A47 DUALLING – NORTH TUDDENHAM TO EASTON

Scheme no. TR010038

COMMENTS on Applicant's replies to ExQ1

On behalf of A.C. MEYNELL of the [REDACTED]

# PROPOSED WOOD LANE JUNCTION

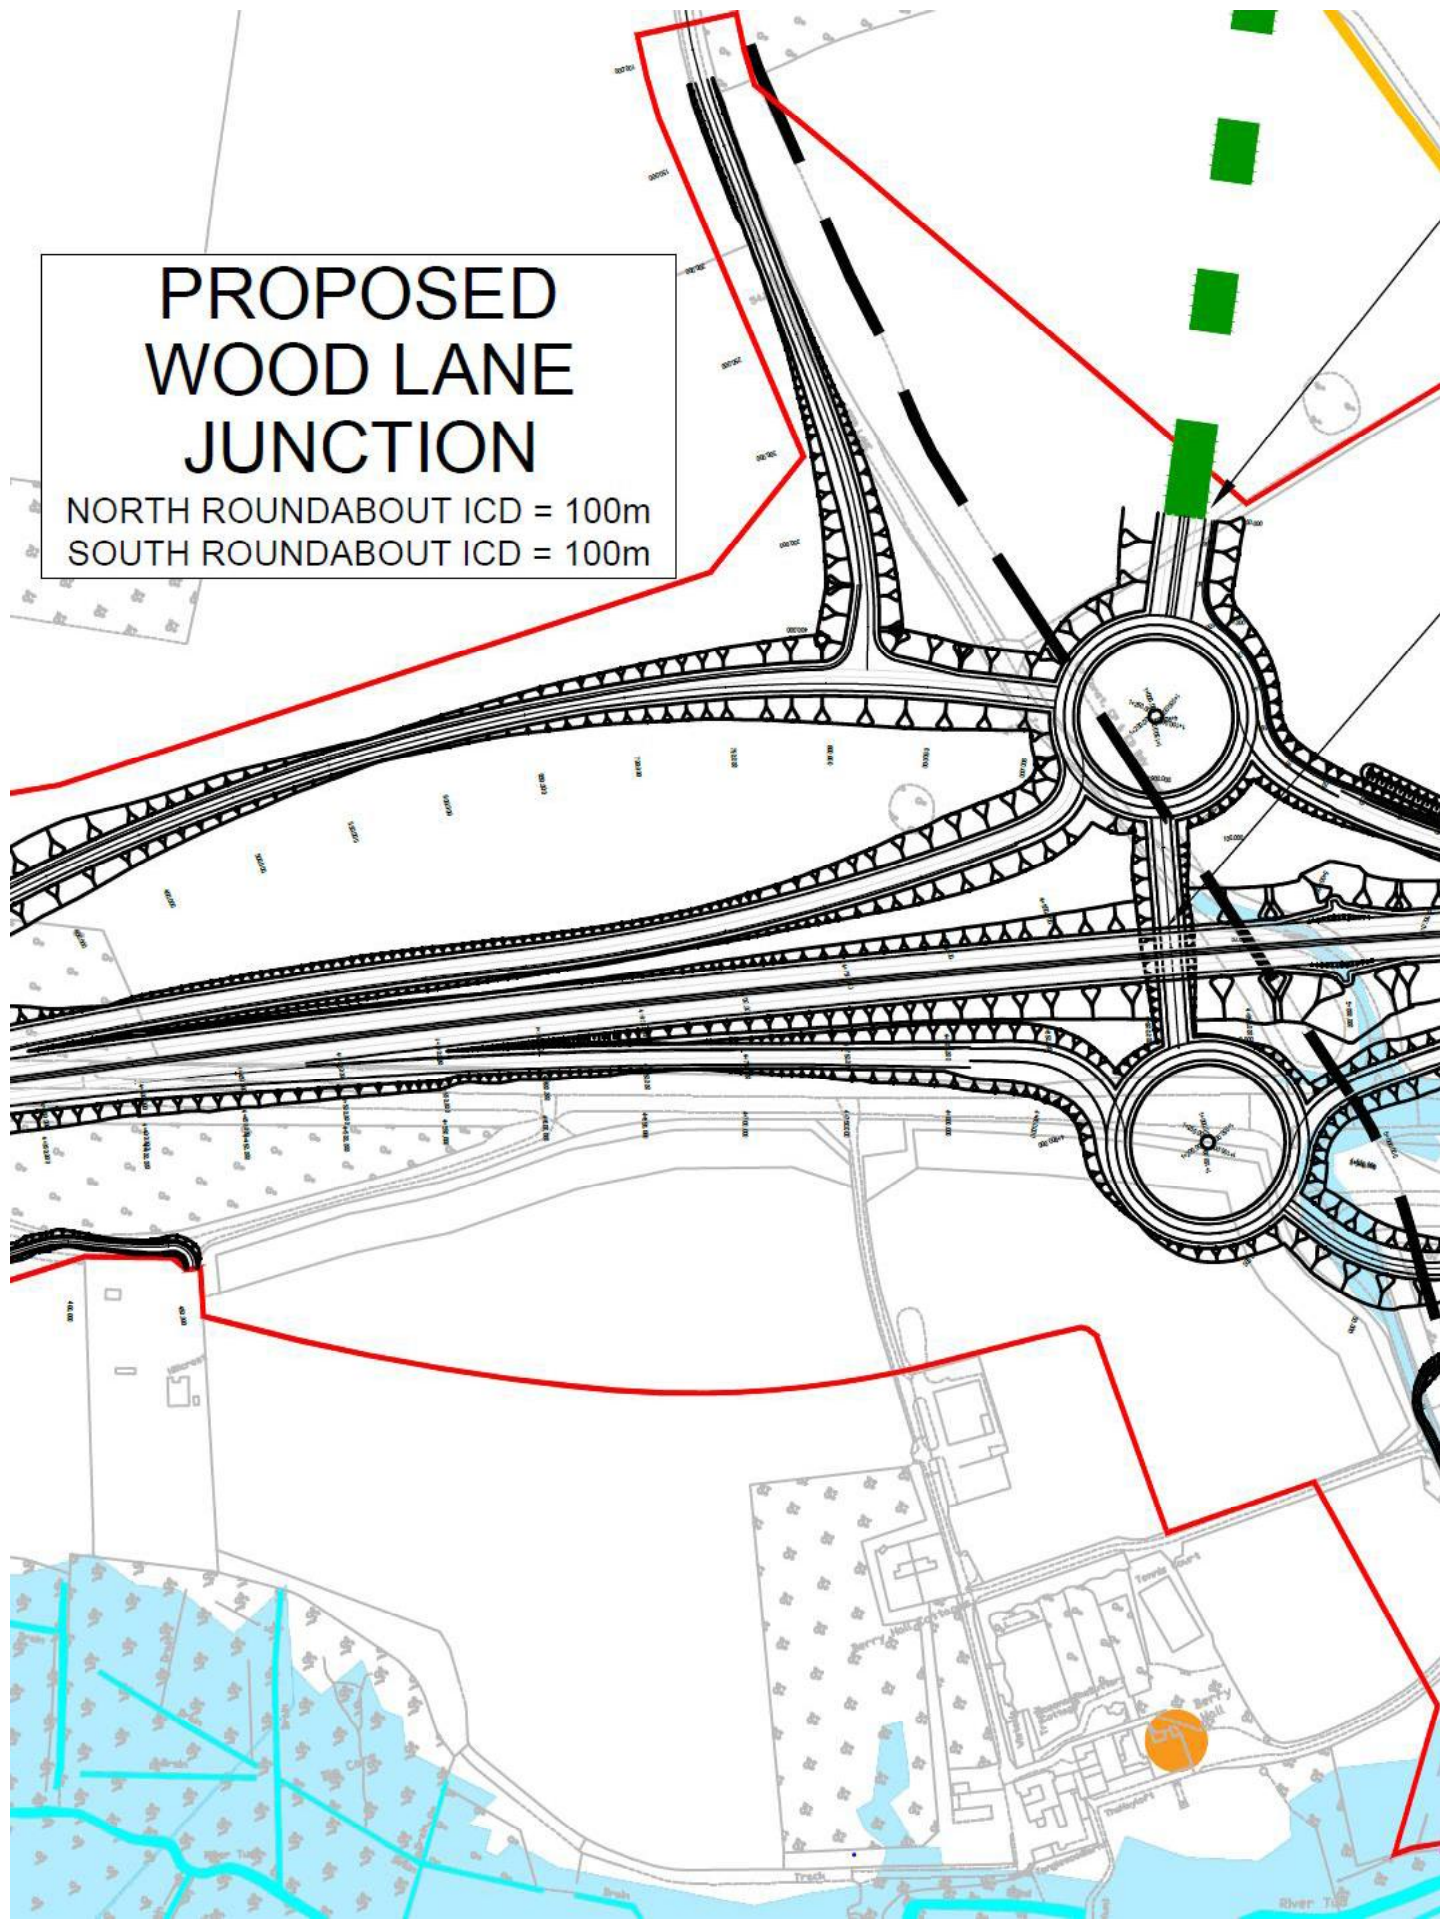
<p>at its chosen location of the parts of the Wood Lane Junction, and how those parts which it has sought to locate on the existing A47 and to its south evolved.</p> <p><i>S of S should take into account the ultimate purpose of the infrastructure and bear in mind the operational, safety and security requirements which the design has to satisfy</i></p> <p>Comment 7: The purpose of the infrastructure was to make a more free-flowing road for traffic using the A47 while minimising the adverse effect of the development on the surrounding landscape and residents. The Applicant's design for and siting of the Wood Lane junction in its precise chosen location fails to fulfil the ultimate purpose for the reasons given above.</p>
--	--	--	--	--	---

are rated "Notable" by the Woodland Trust and one as a Veteran. Of the 52 Grade B trees to be felled 19 (one third) are within the Wood Lane Junction.
				3.6 Good Road Design is restrained	Comment 11: For the reasons given in the previous comments 9 and 10 above, the Wood Lane junction design in its proposed location is not restrained.

<p>3.6.1 Sections 4, 5 and 6 of this report outline the considerations applied during the design of the junctions, side roads and structures forming the Scheme to minimise the potential impact on existing infrastructure...</p> <p>... and the environment.</p>	<p>Comment 12: The Wood Lane Junction does not minimise potential impact on existing infrastructure.</p> <p>(1) The position of the east-going link road from the south dumbbell and the demolition of the existing A47 east of the junction to allow for the westbound off slip road, requires a doubling of the distance for which the National Grid Gas Main has to be diverted, over that which it should be possible to achieve in the BHE alternatives.</p> <p>(2) the positioning of the south dumbbell over the existing junction requires diversion of the Anglian Water Main and the underground E-W BT cables on the A47, neither of which should be required at the junction in the BHE alternatives. (see the utilities plans at Appendix E to the Scheme Assessment Report - at Highways England 2020 consultation docs)</p> <p>(3) Again by placing the South dumbbell over the existing junction, the Applicant removes the head of the existing drainage channel from the 1968-improved A47 to the river Tud on the east side of Berry's Lane, which is retained in the BHE alternatives.</p> <p>(4) the placing of the South dumbbell over the existing junction and demolition of the north end of Berry's Lane, has led to the perceived need for the construction of the proposed cycle path from Berry's Lane to Dereham Road. Retention under the BHE alternatives of the existing Dereham Road and Berry's Lane (the latter for NMU's and tractors only) minimises the disruption to existing infrastructure and removes the need for a cycle path, allowing the well-used natural public footpath to remain, together with its connection to the BHE permissive footpath over meadows to the River Tud which the Applicant's design proposes to sever.</p> <p>Comment 13:As to the environment, the impact is not minimised at the Wood Lane Junction, for the reasons given in all comments above.</p>

<p>3.6.2. The new A47 will be predominantly offline... therefore enabling the use of the existing A47 during construction to minimise disruption to road users.</p>	<p>Comment 14: The new A47 is not offline at or either side of the Wood Lane Junction as designed and located by the Applicant. The south dumbbell is on the A47 as are part of the slip-roads on the south side. A portion is also being demolished in order to tie in the proposed new link road east to the detrunked A47. The Applicant's location and design for the junction prevents the use of the existing A47 during construction of these elements at or either side of the Wood Lane Junction due to this and to the diversion of utilities at the junction.</p> <p>During construction in this phase (Phase 3 per Annex B to REP2-014)) the existing A47 traffic is be diverted off the existing A47 through part of the new dualled highway east of the junction, then through part of the junction itself and then along the new link road to the north of the new road leading to Sandy Lane when that is completed, in order to construct the elements on the existing road.</p> <p>The BHE Option A proposal allows the retention of those parts of the existing A47 with construction of the Lady's Grove underpass, for the whole construction period until ready to travel on the new dual carriageway or part of it.</p>
